Our Ref: FP/118/20/NMA

Non material amendment following the grant of FP/192/19/HH for the addition of first floor dressing room obscured glazed window, only openable above 1.7m above finished floor level & alteration to family bathroom window to be obscured glazed & only openable above 1.7m above finished floor level.
Bright Side 5 Rudwicks Close Felpham PO22 7NG

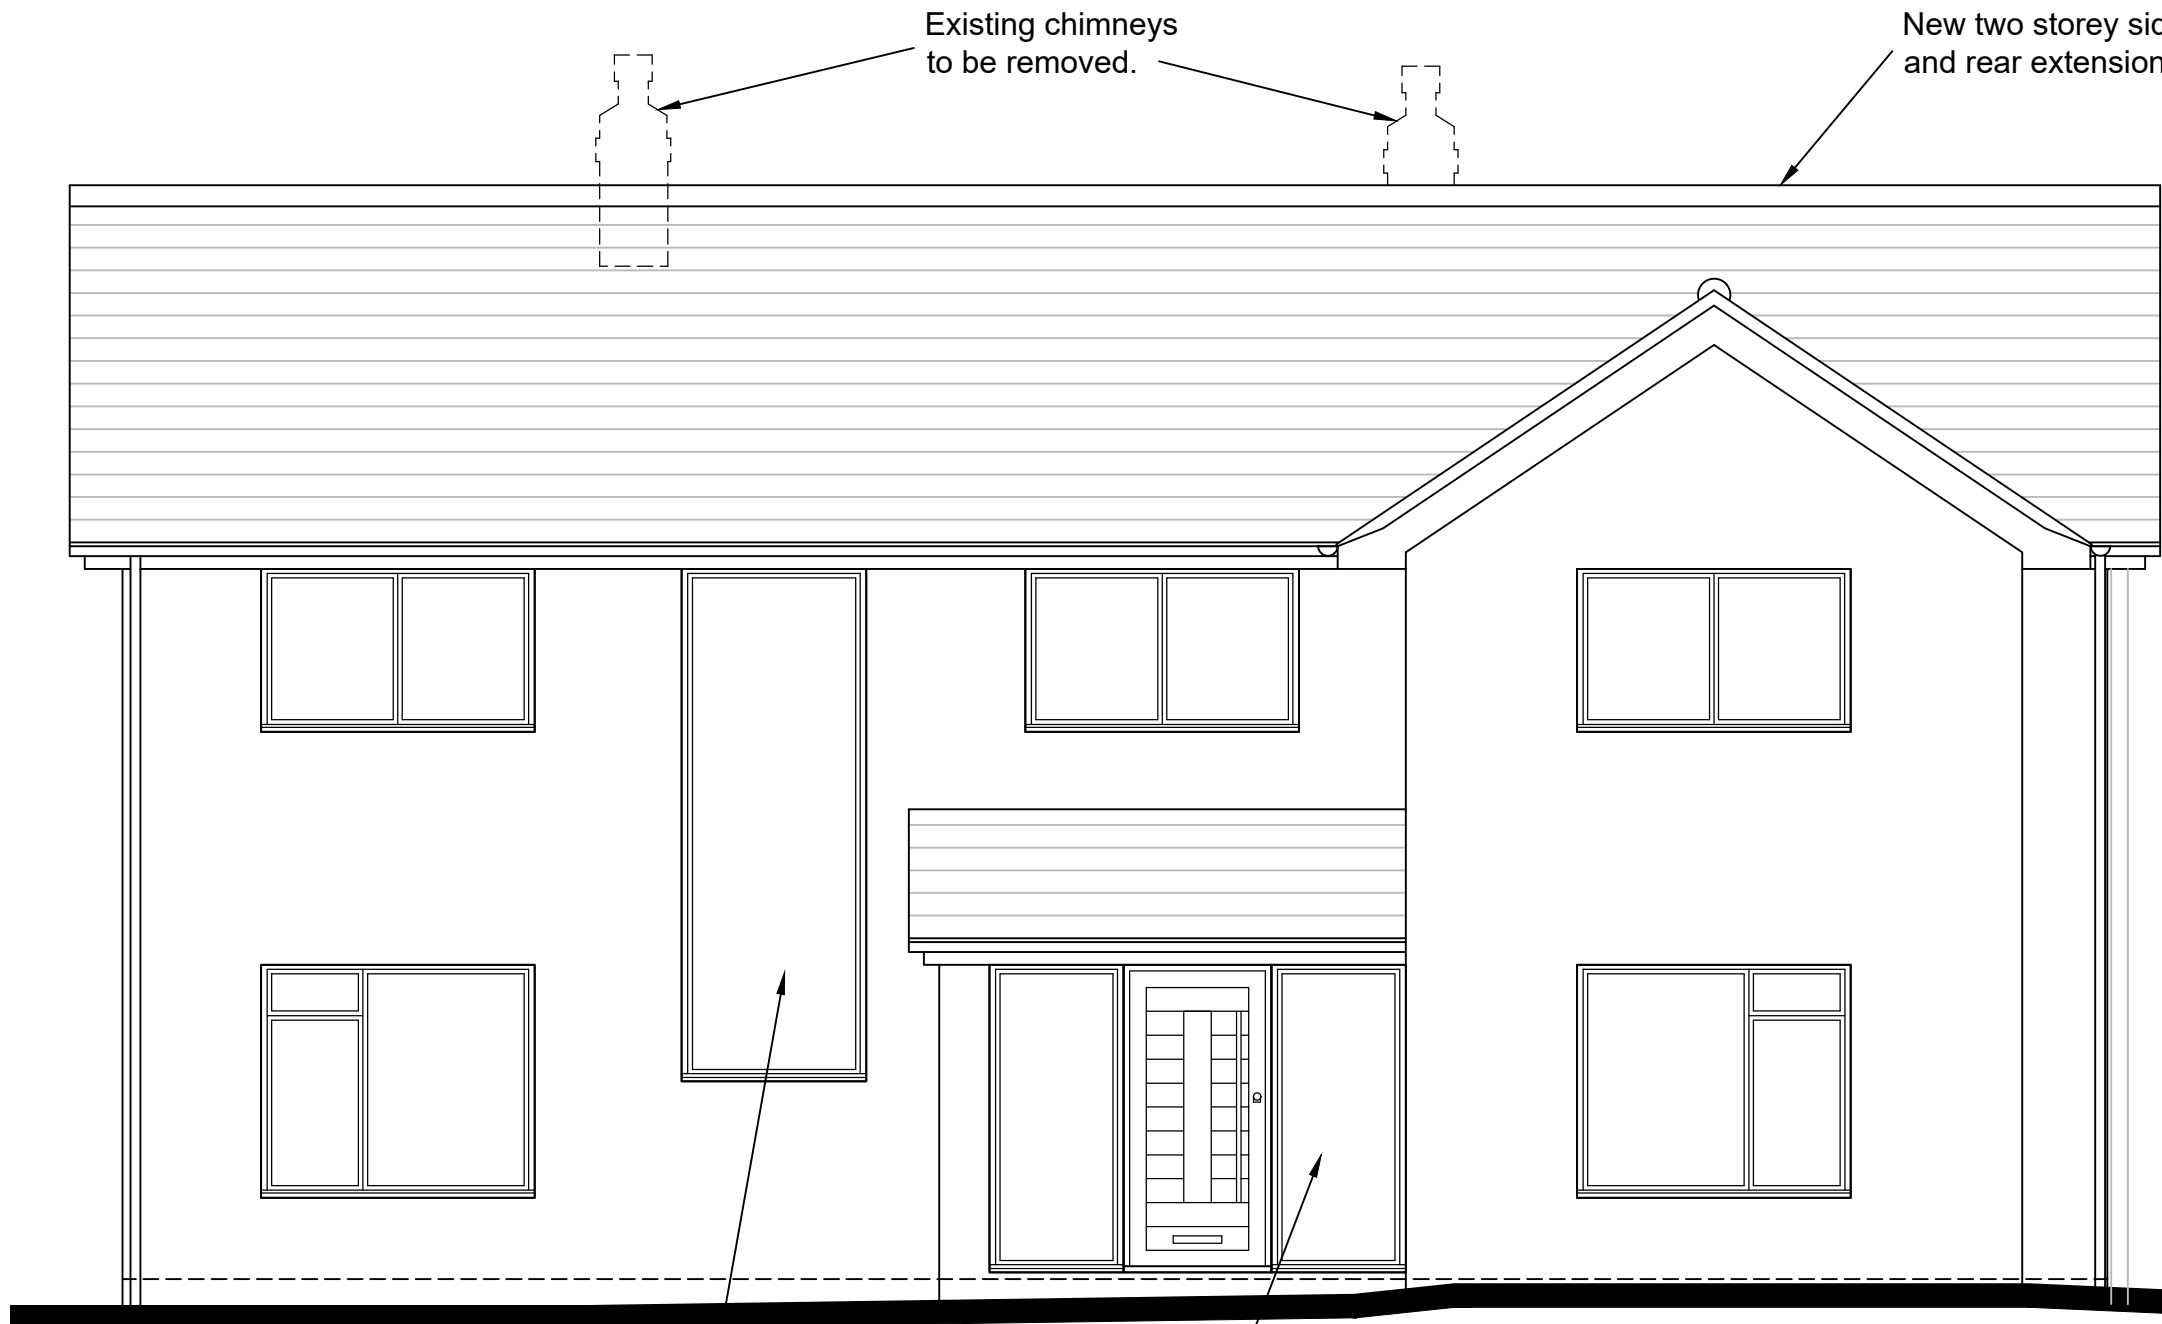
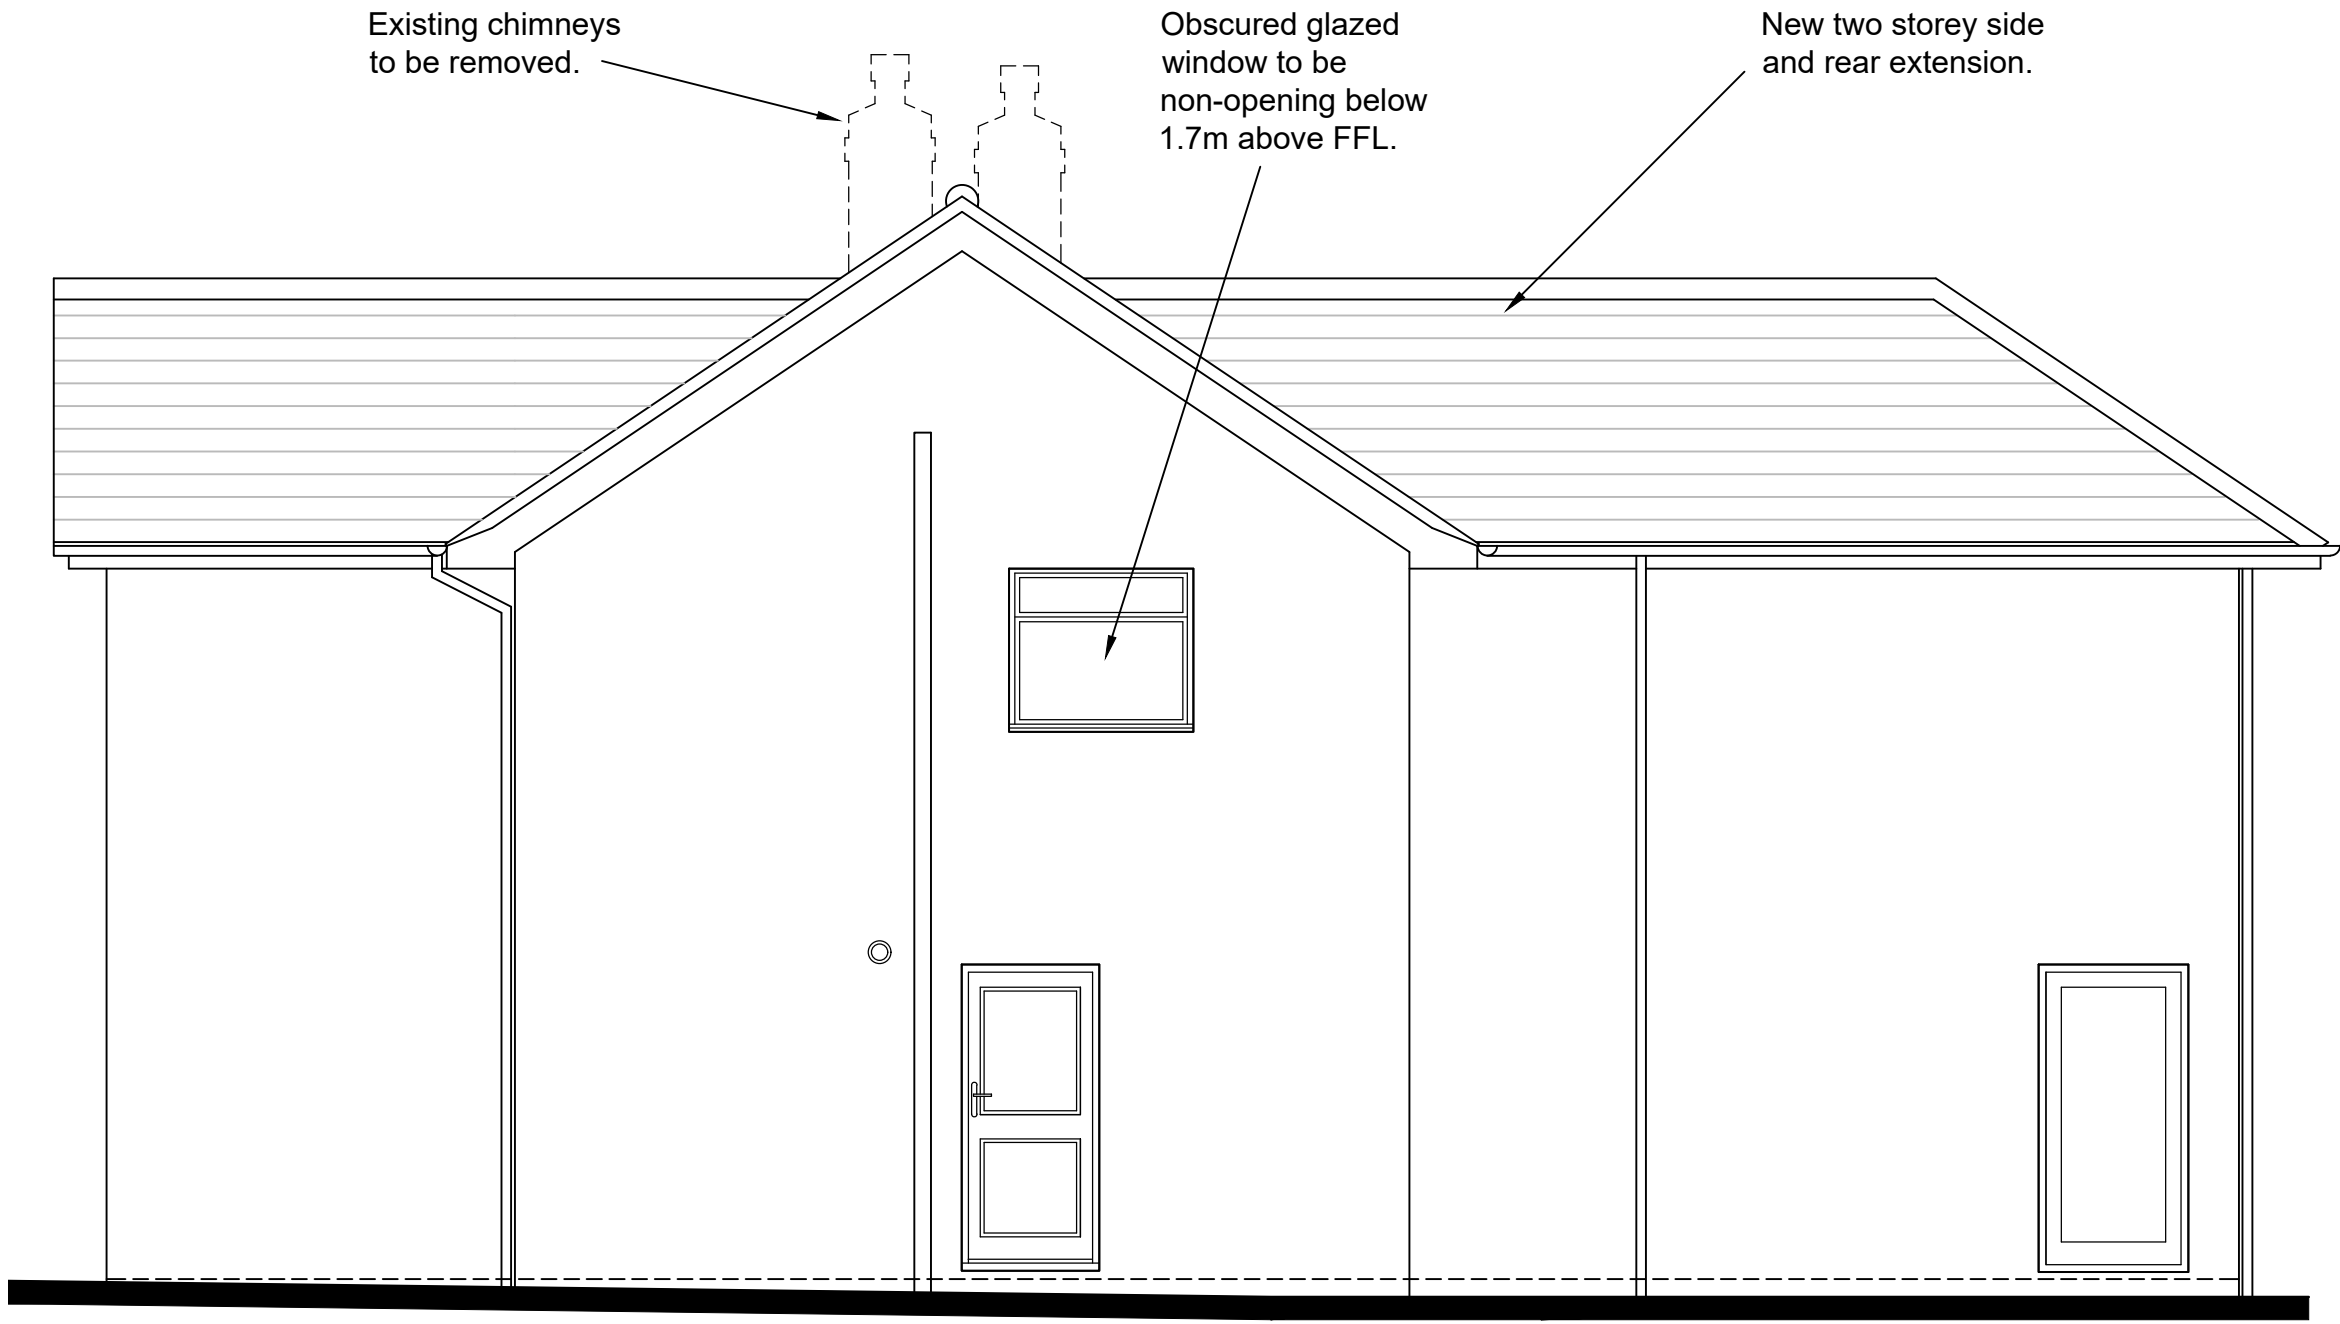
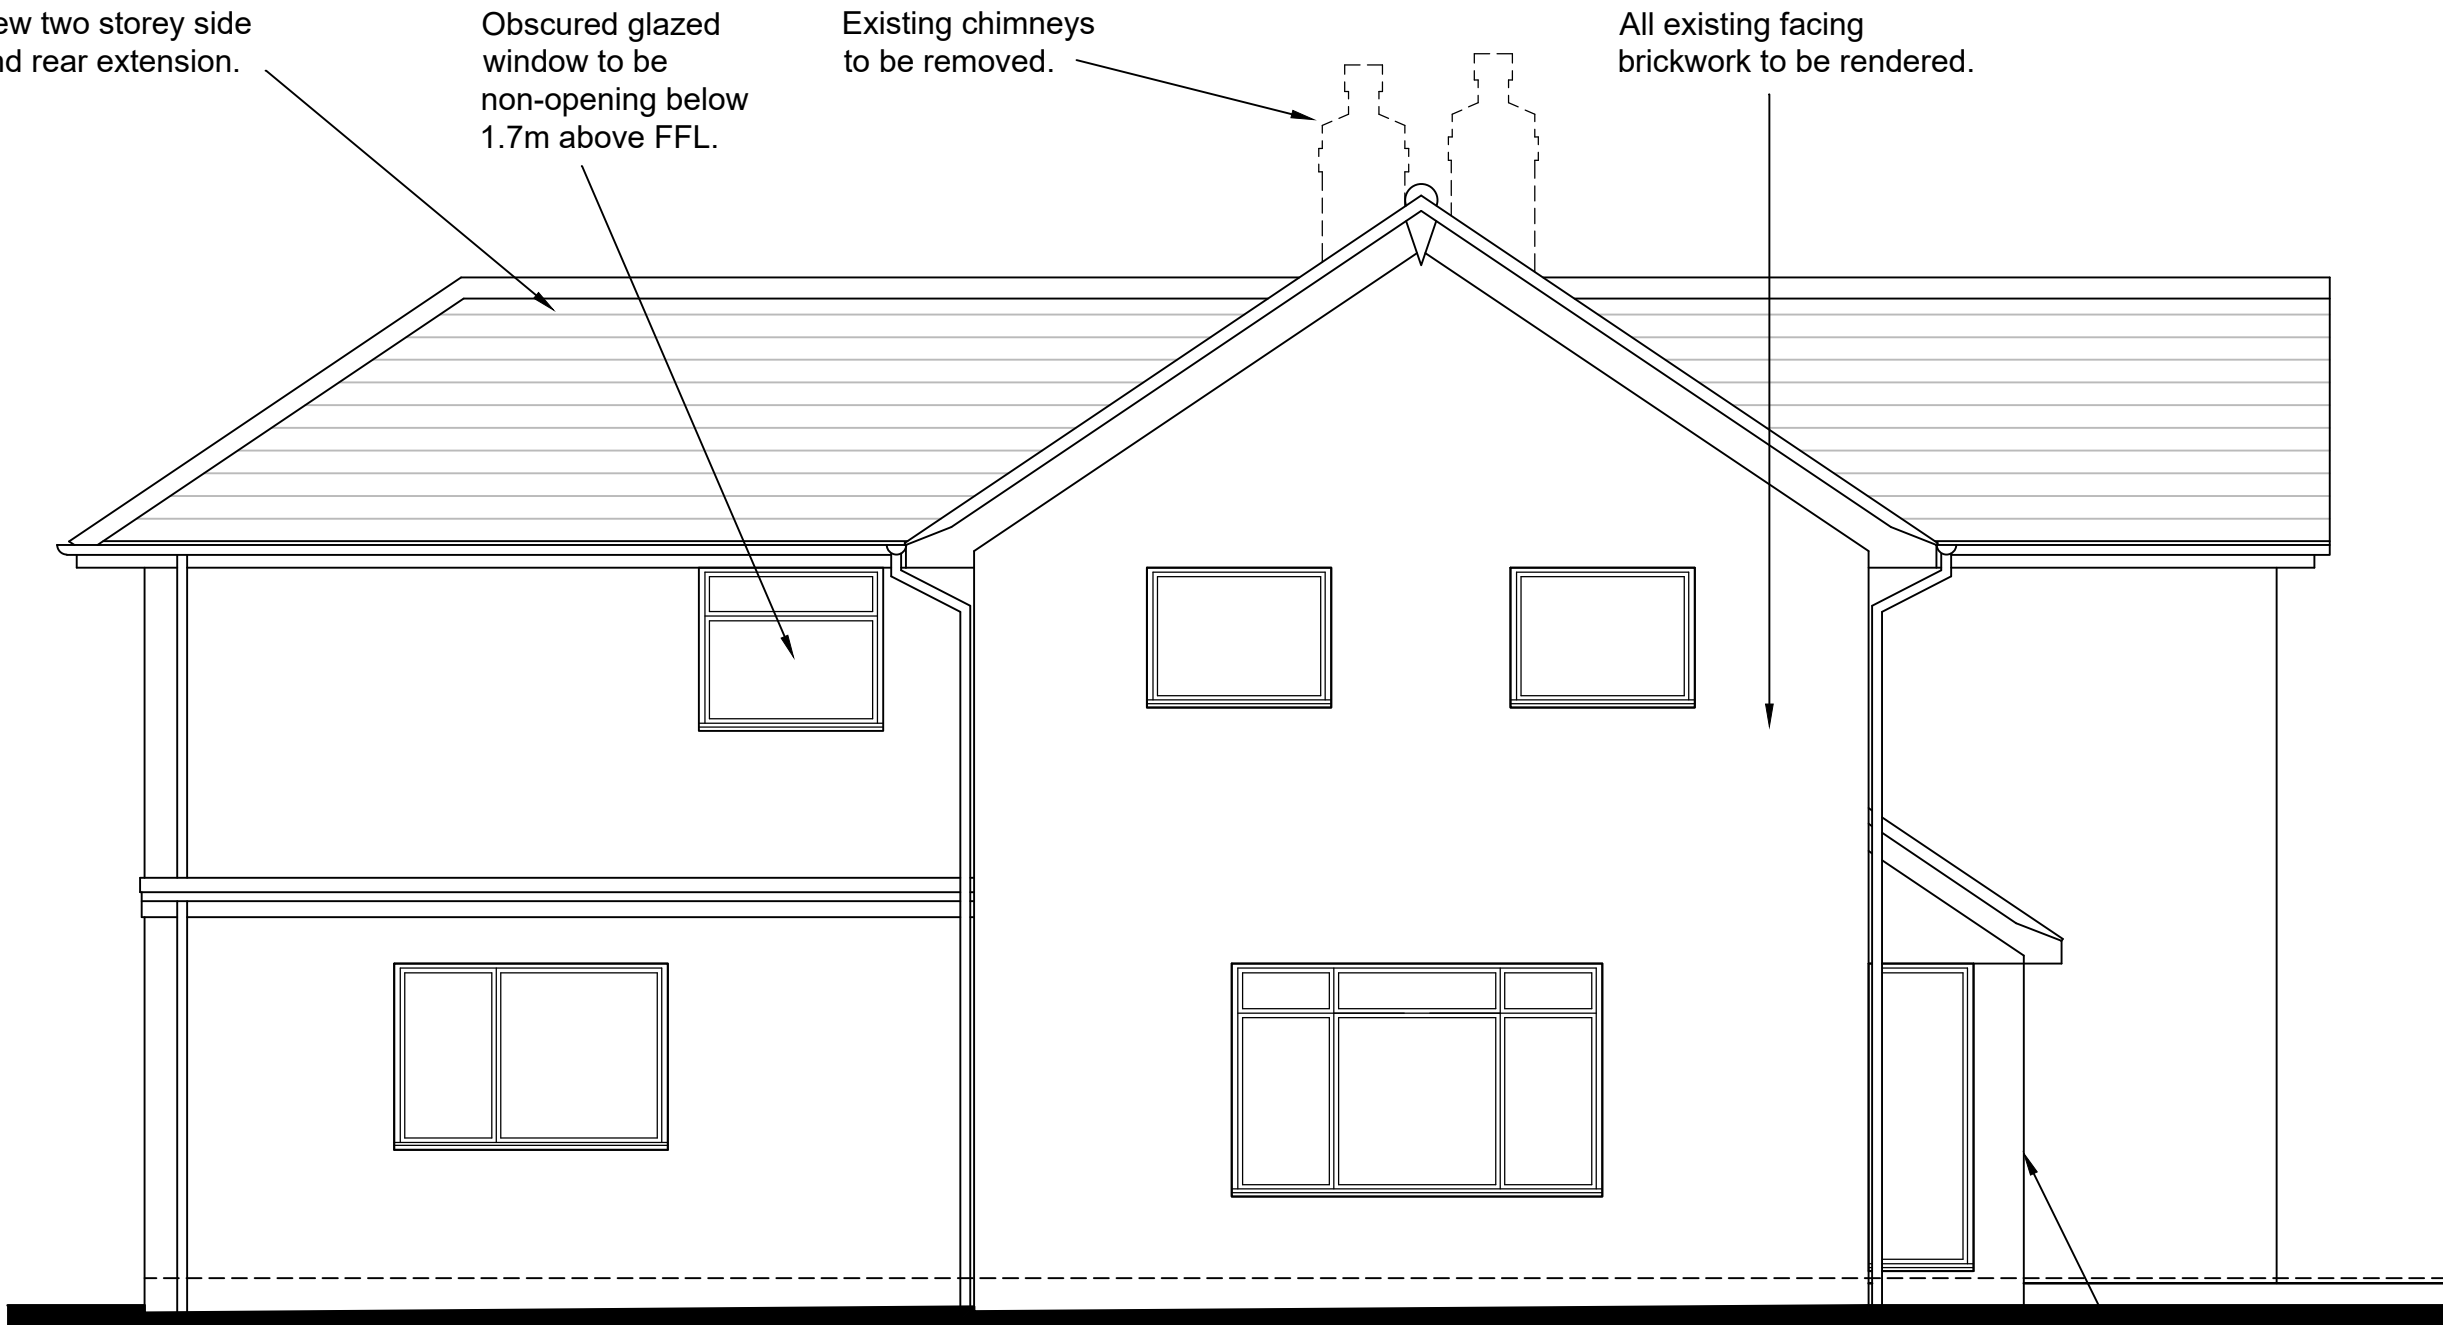
The reasons that these proposals have not been accepted as a Non-Material Amendment is because the dressing room window is likely to have the potential to overlook the rear gardens of the properties to the side, located in Limmard Way. Whilst it is proposed to be obscured glazed, the LPA would not being able to enforce this.

Alternatively, a window could be introduced to the side elevation after the build under permitted development which in order to comply with criteria would be required to be obscured glazed.
